DECISION DELEGATED TO HEAD OF PLANNING

Application No: H11-0780-23 **Applicant:** Mr K Bunn
Proposal: Proposed conversion of dwelling into 1 new house and 2 new flats
Location: 12 Park Lane Long Sutton Spalding
Terminal Date: 1st November 2023

GROUND FLOOR PLAN

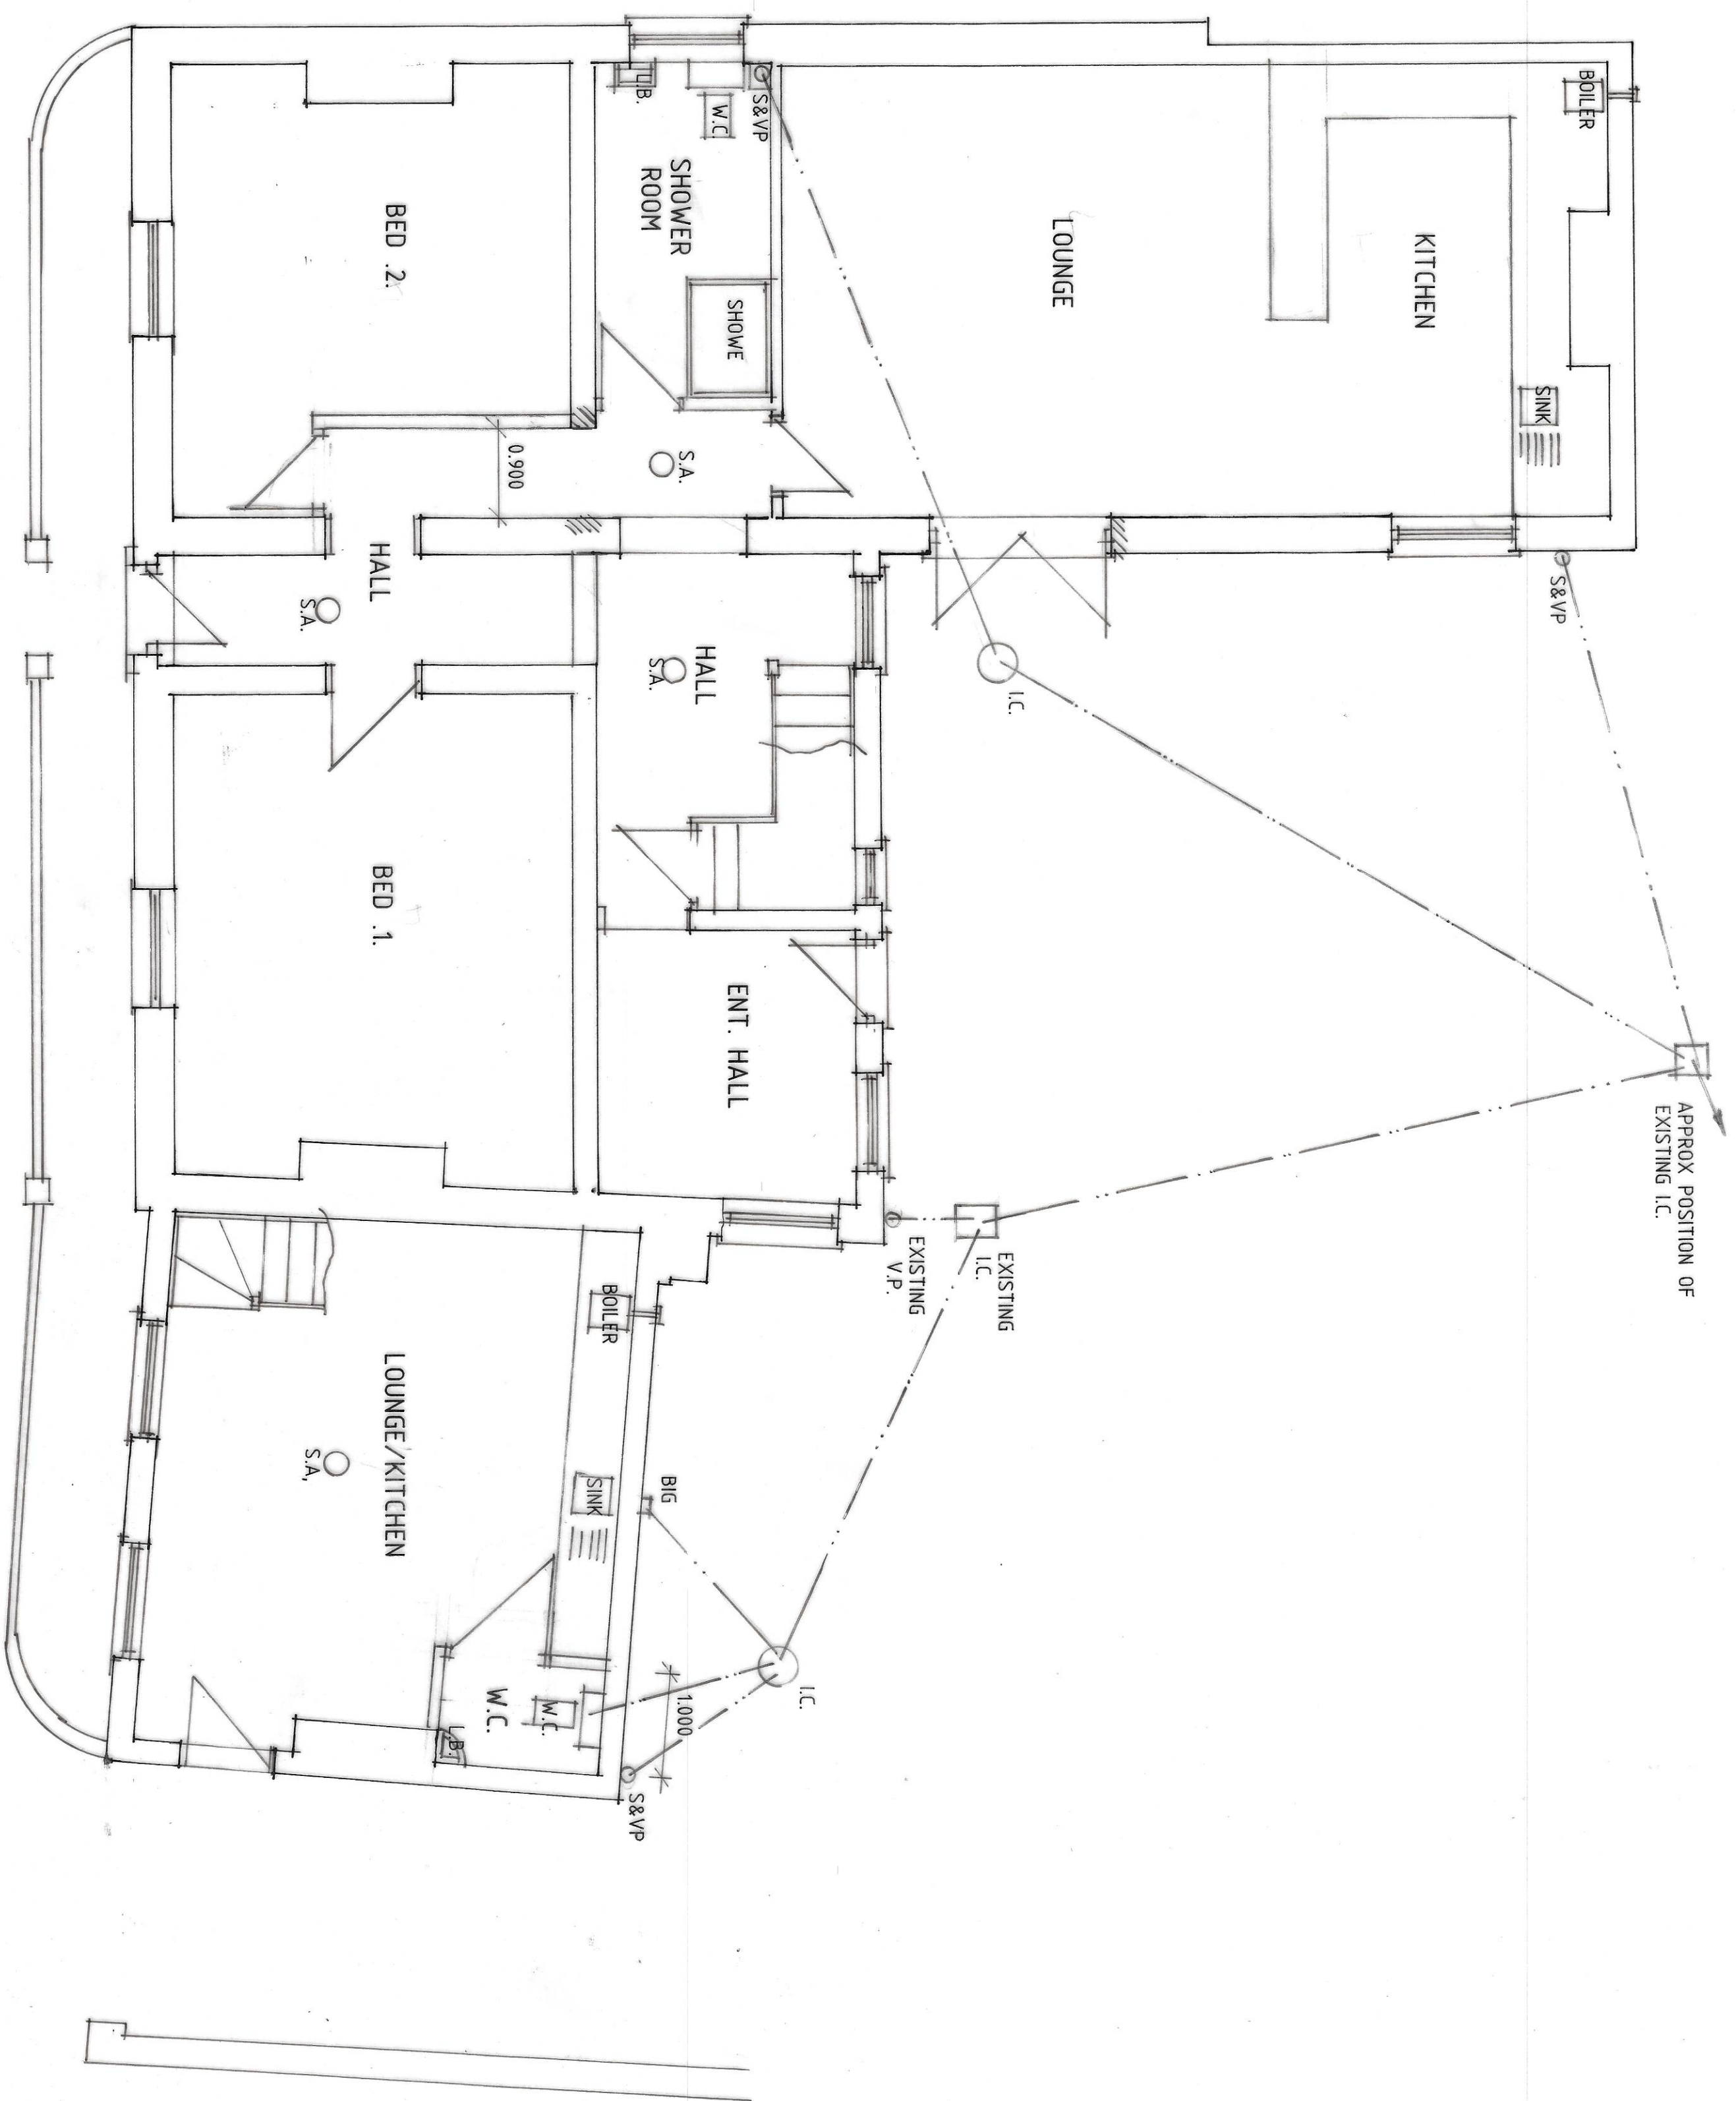
The proposed internal gross floor area of the one bedroom house falls short of the nationally described minimum space standards by a significant amount. The internal floor space is 50.4 square metres, where a two storey one bedroomed dwelling should be a minimum of 58 square metres.

Whilst it is acknowledged that the ground and first floor flats adhere to the national minimum space standards, the level of amenity for future occupiers for the proposed one bedroom house is considered to be inadequate and poorly designed. Such a stark deficit in minimum floor space would result in poor living conditions. The proposal is in conflict with Policy 21 as a result and related Policies 3 of the SELLP in that the proposal does not create a distinctive places through the use of high quality and inclusive design and layout and Policy 2 in that it adversely affects the character and appearance of the area due to its poor quality of design.

The proposed alterations involve the replacement of windows with non-traditional materials as well as the blocking up of doorways and creation of new openings, notably replacing an original window with French windows. NPPF 2023, para 194 states: 'In determining applications, local planning authorities should require an applicant to describe the significance of any heritage assets affected, including any contribution made by their setting. The level of detail should be proportionate to the assets' importance and no more than is sufficient to understand the potential impact of the proposal on their significance. As a minimum, the relevant historic environment record should have been consulted and the heritage assets assessed using appropriate expertise where necessary.'

PROPOSED
FIRST FLOOR PLAN

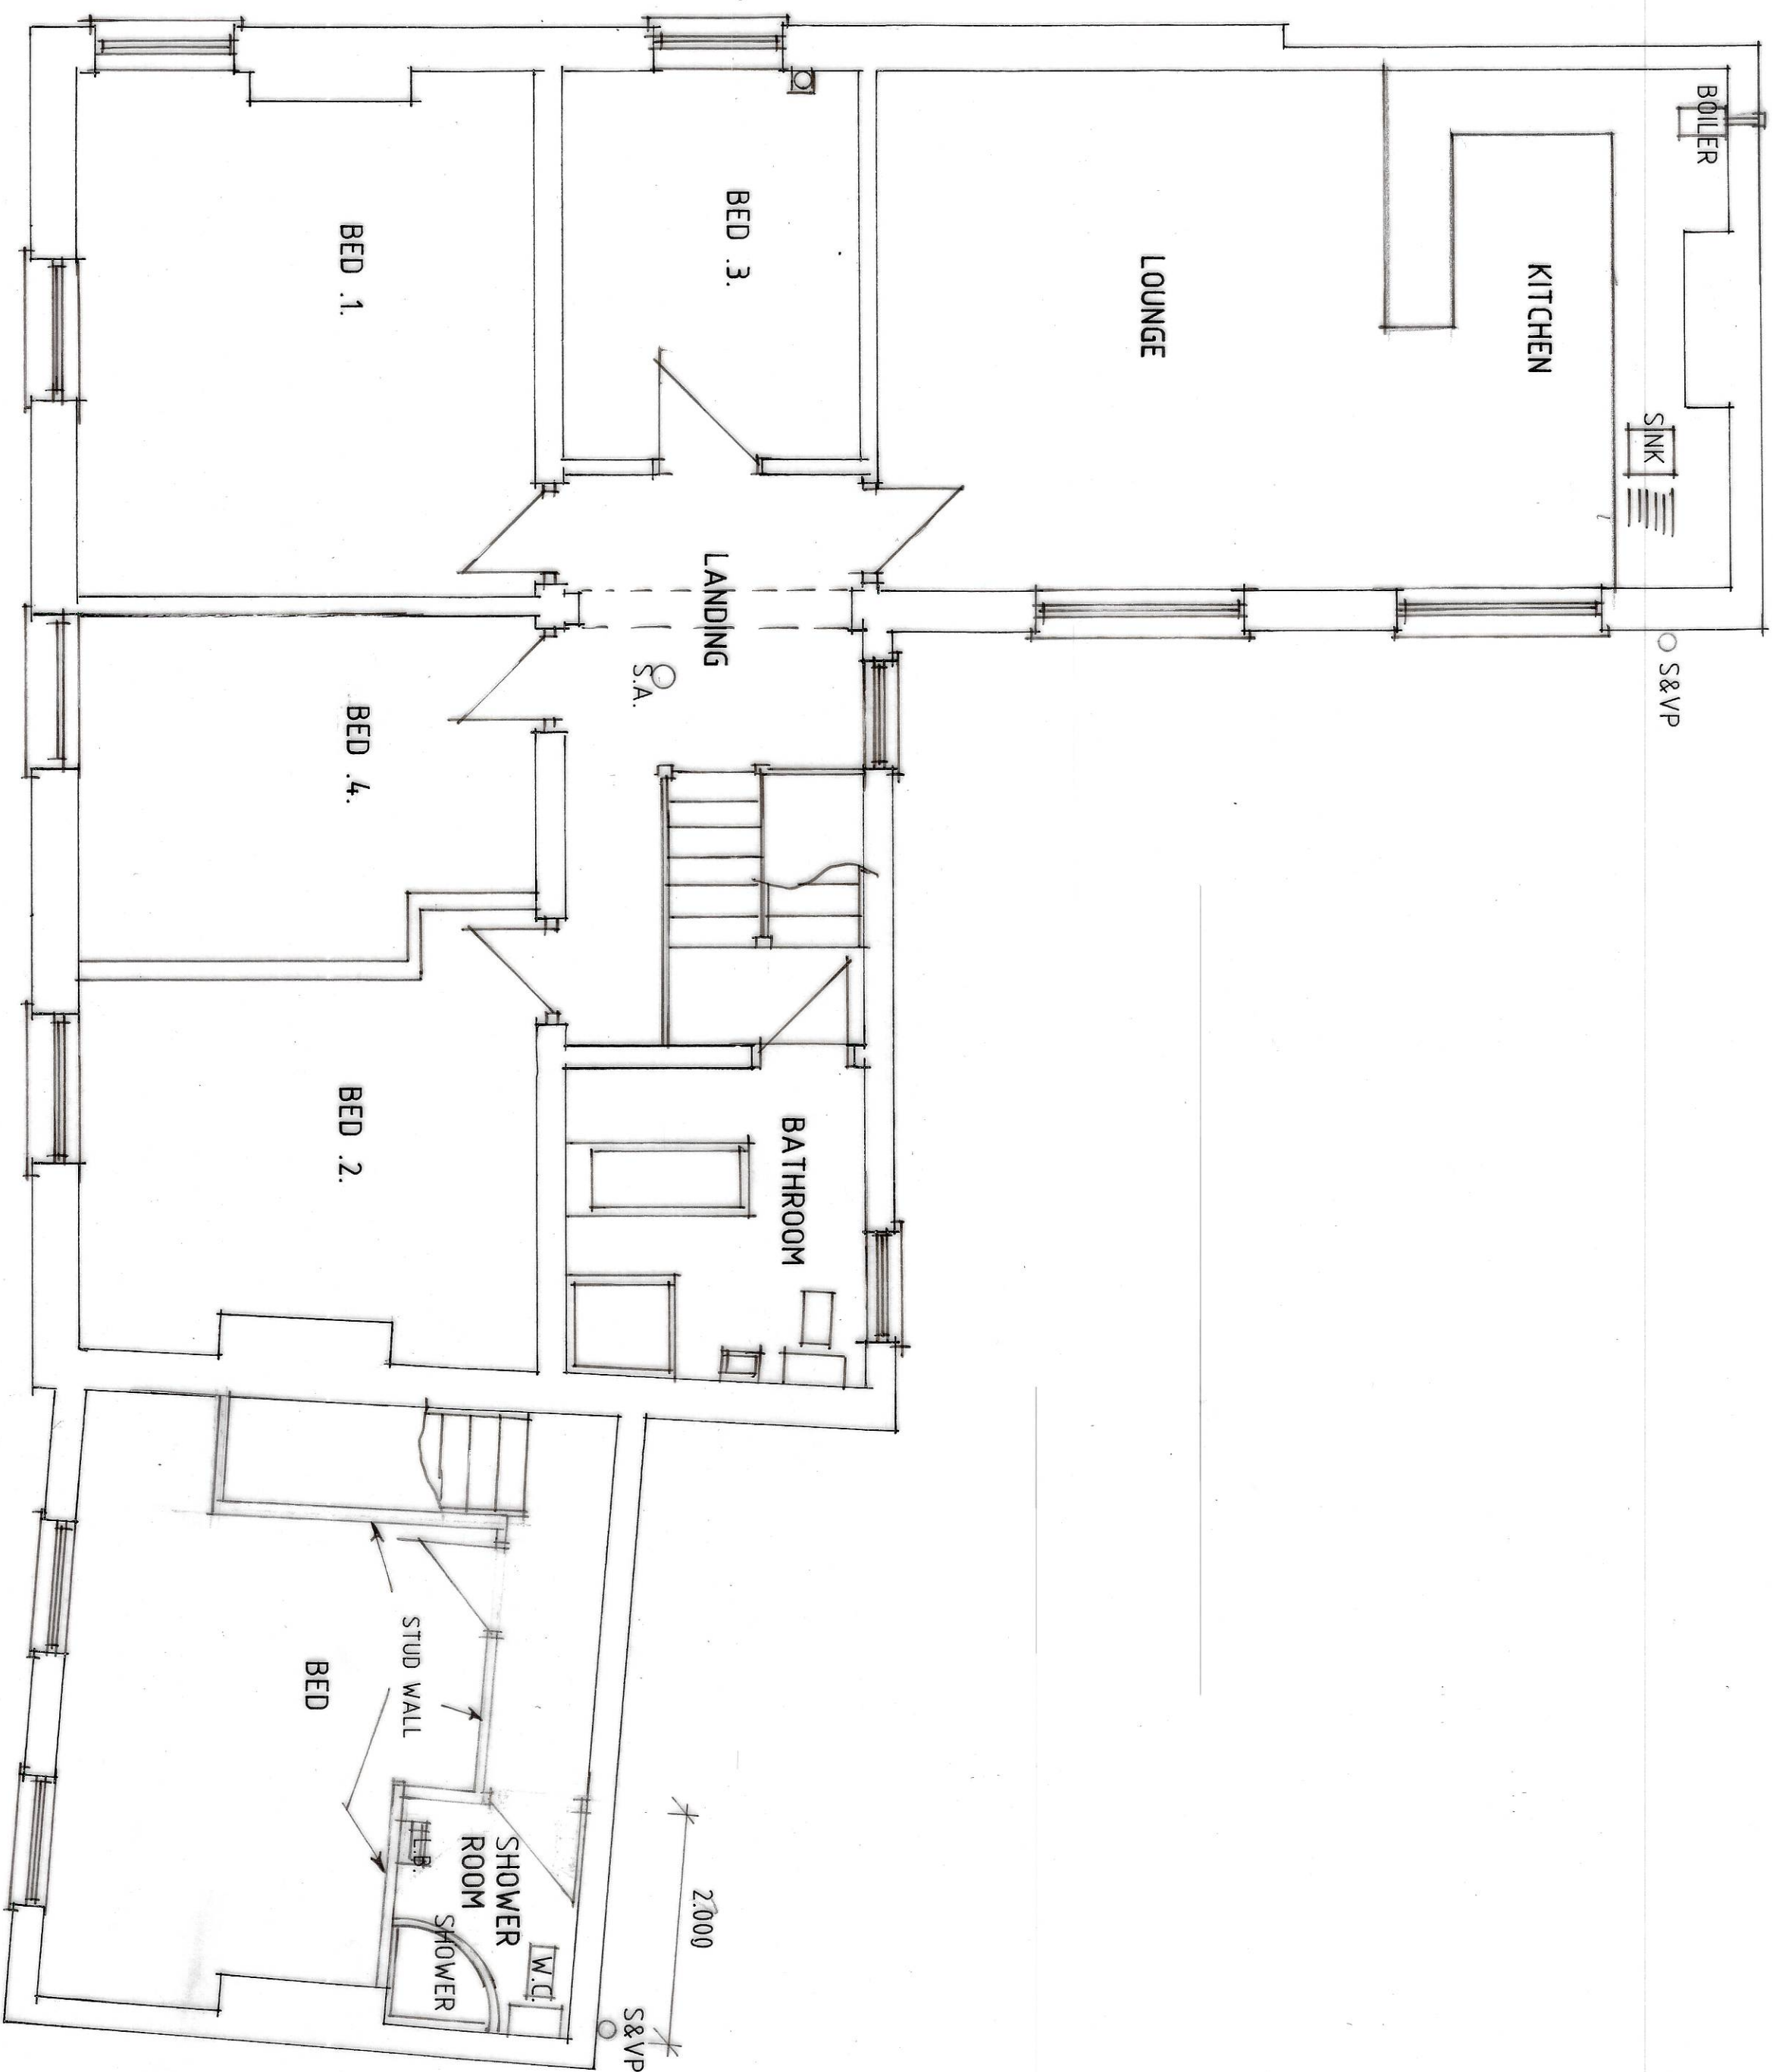
The proposed internal gross floor area of the first floor four bedroom flat measures 110 square metres whereas the nationally described minimum space standards requires at least 108 square metres. This is therefore above the minimum standard.
